## **Letter to the Applicant from National**

11 July 2022

**Ref: SUNNICA ENERGY FARM**

Drawing Title
FIGURE 2-9
SUNNICA WEST
CABLE CORRIDOR

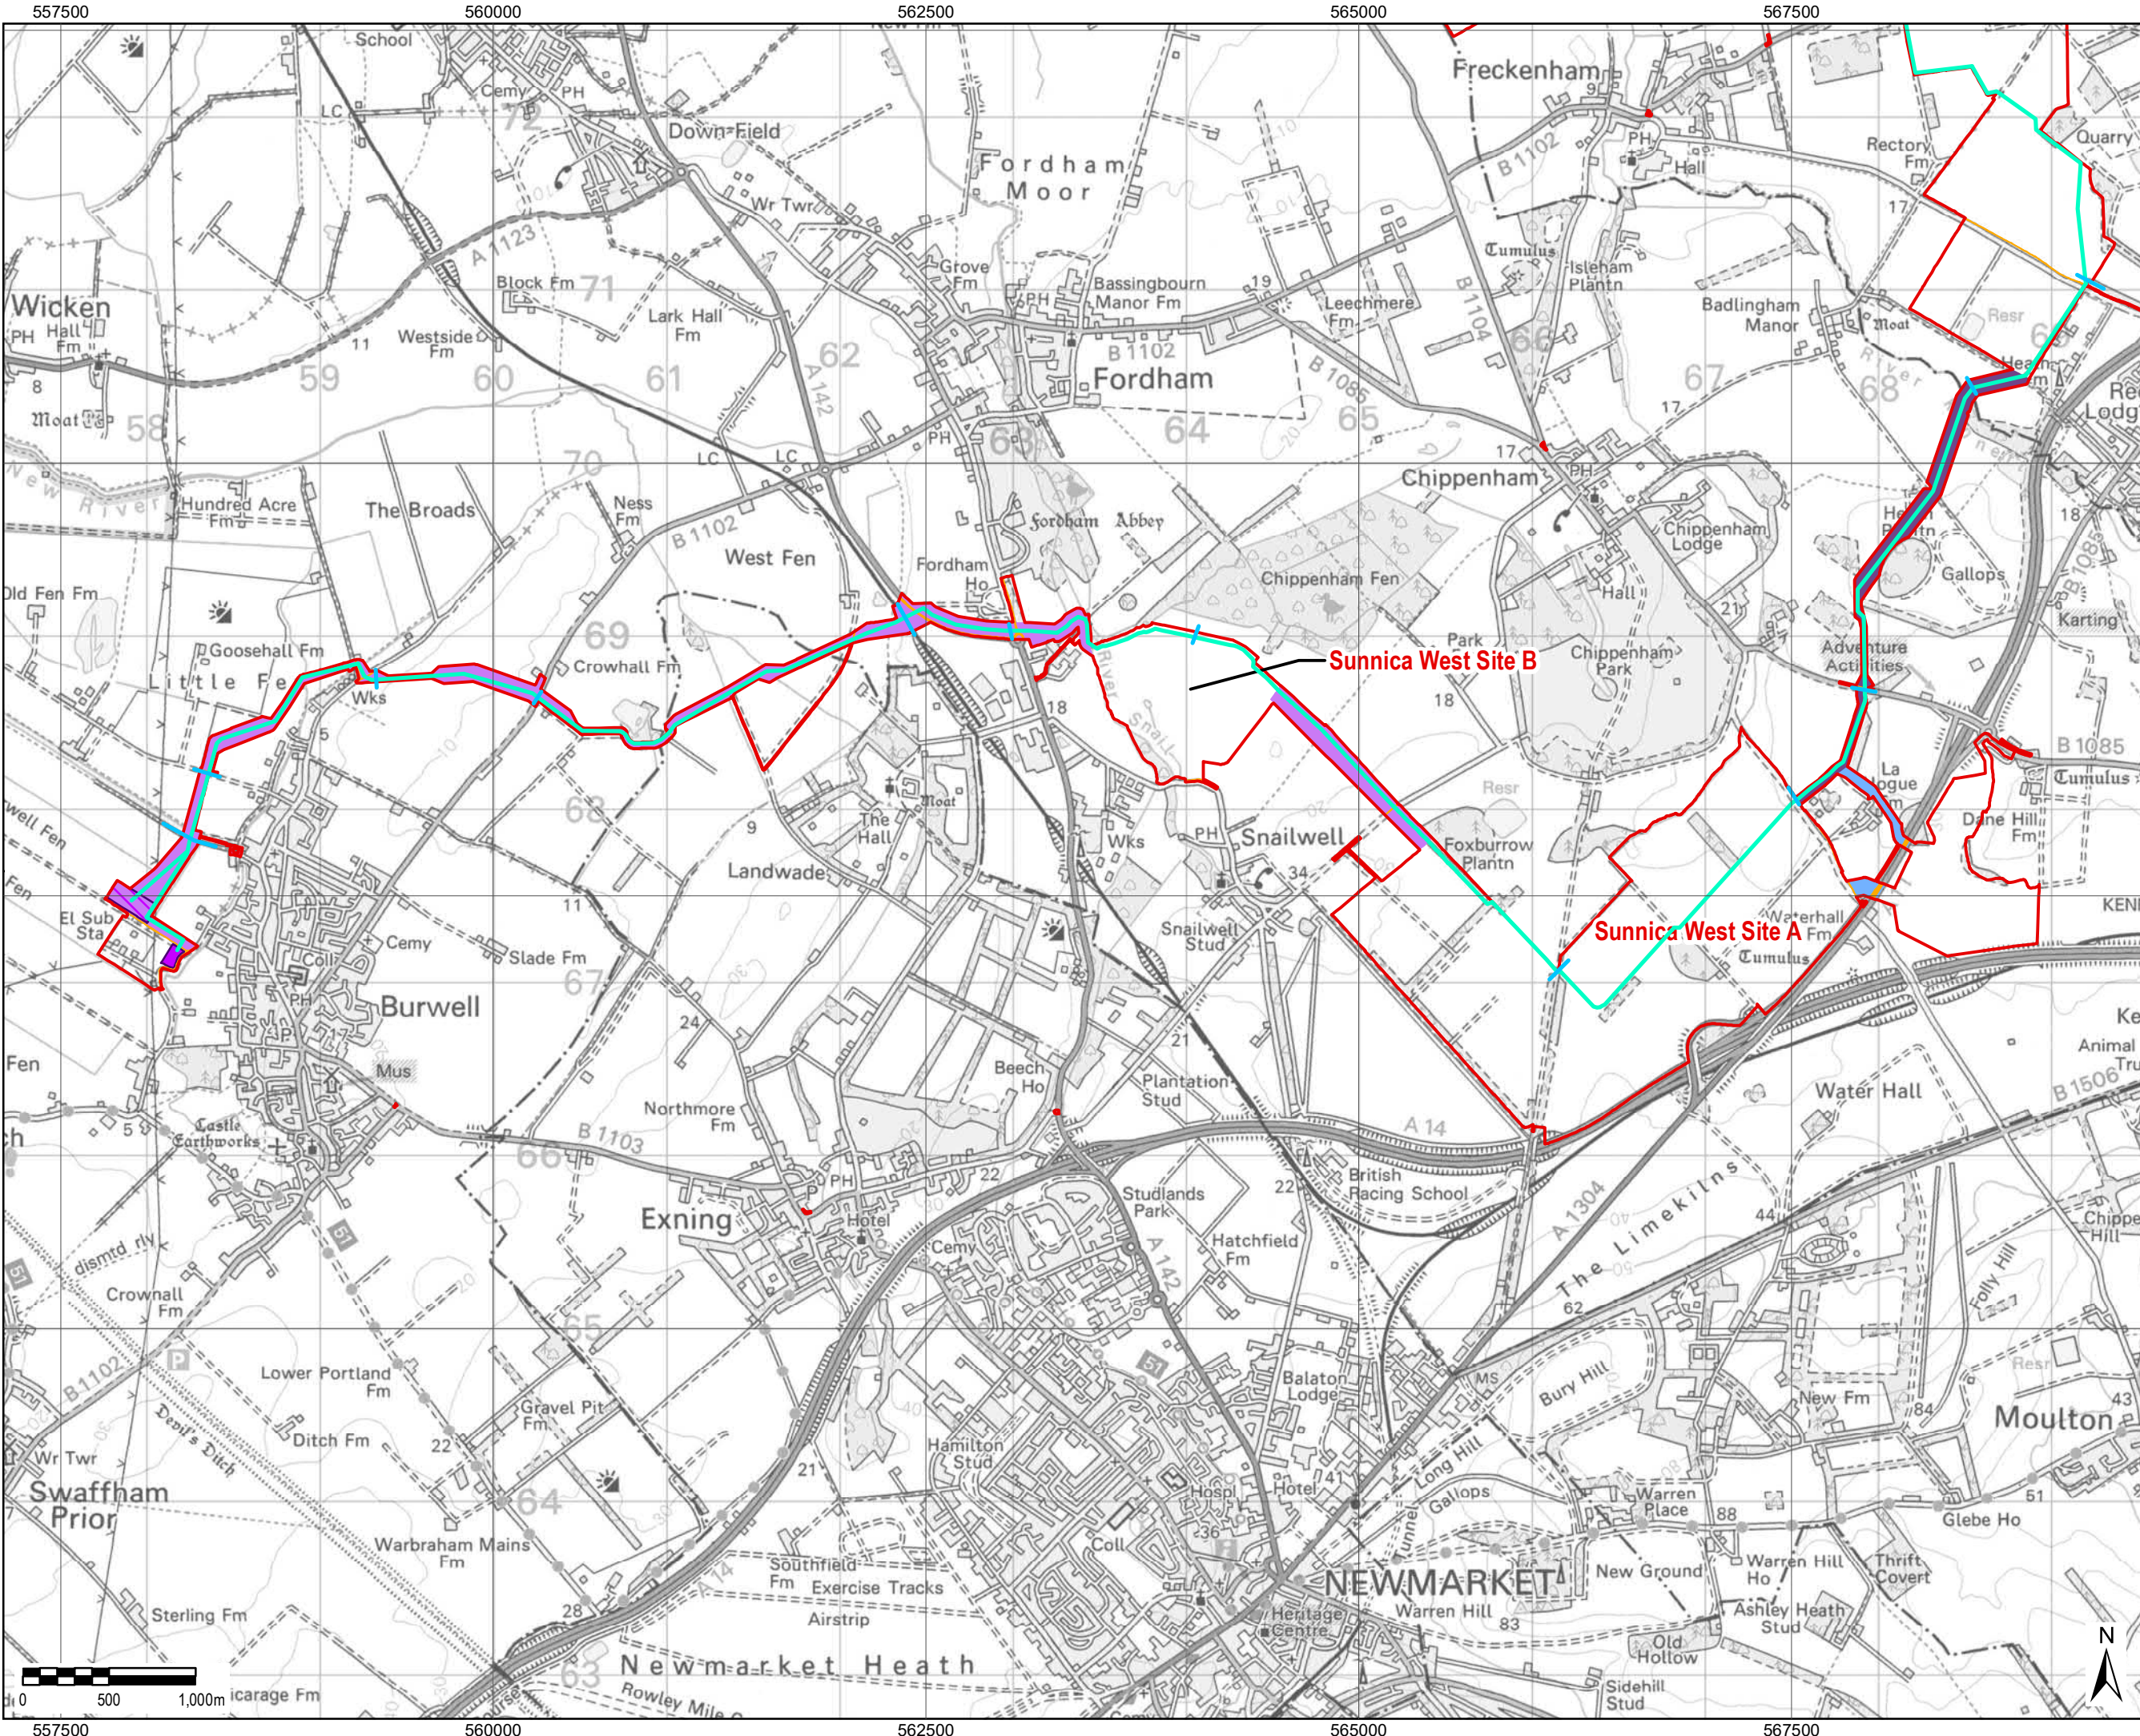
As part of the feasibility process, NGET reviewed the submitted DCO documents, including the proposed plans for the Option 1 connection. In undertaking this review and in the context of NGET's statutory obligations, NGET concluded that unfortunately a connection at Option 1 would not be technically feasible.

- that the land requested by Sunnica for their substation to be provided pursuant to the DCO was larger than originally discussed between NGET and Sunnica; and
- In addition, NGET must meet requirements to provide other connections at the Burwell Main Substation site. To facilitate this, as Sunnica is aware, NGET is undertaking an extension of the substation. the land required for this will mean that the Option 1 connection is not possible.
